SITE PLAN

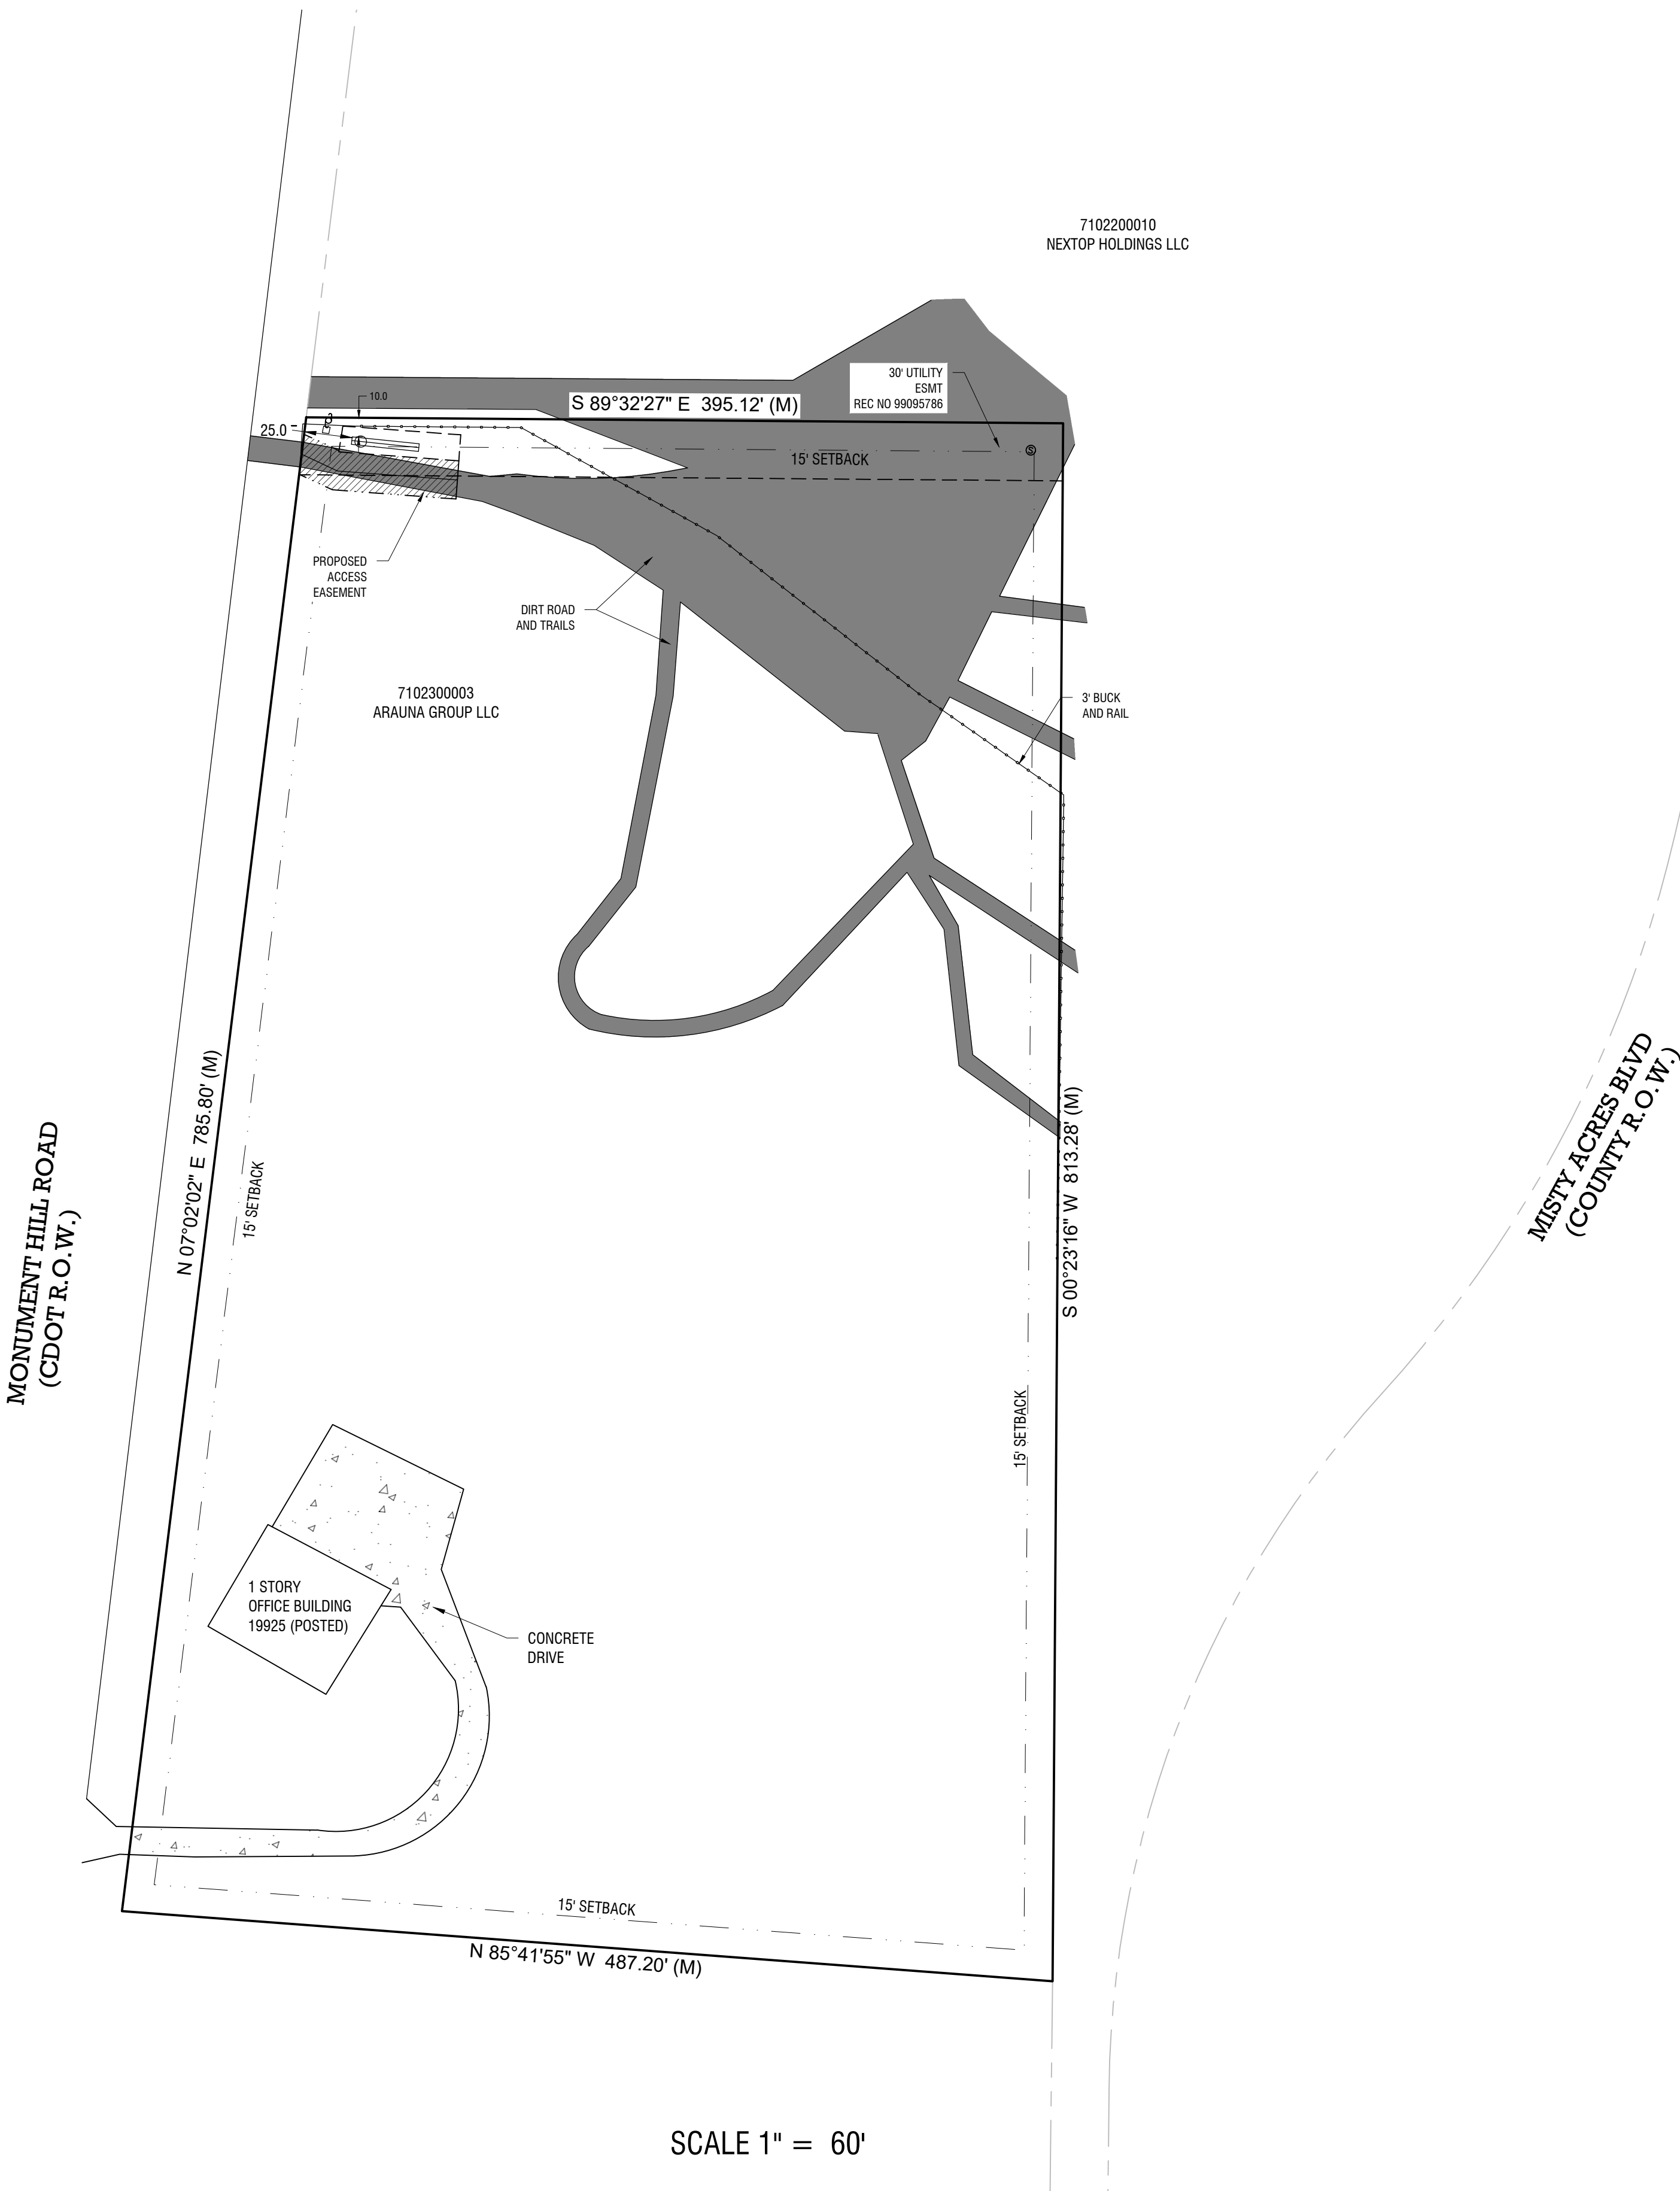
Please specify the no-build, floodplains, and drainage facilities.
.if none, then specify there are none

Please revise Misty Acres Blvd is county right-of-way for the section shown.

Please add "PCD File No. AL-22-011".
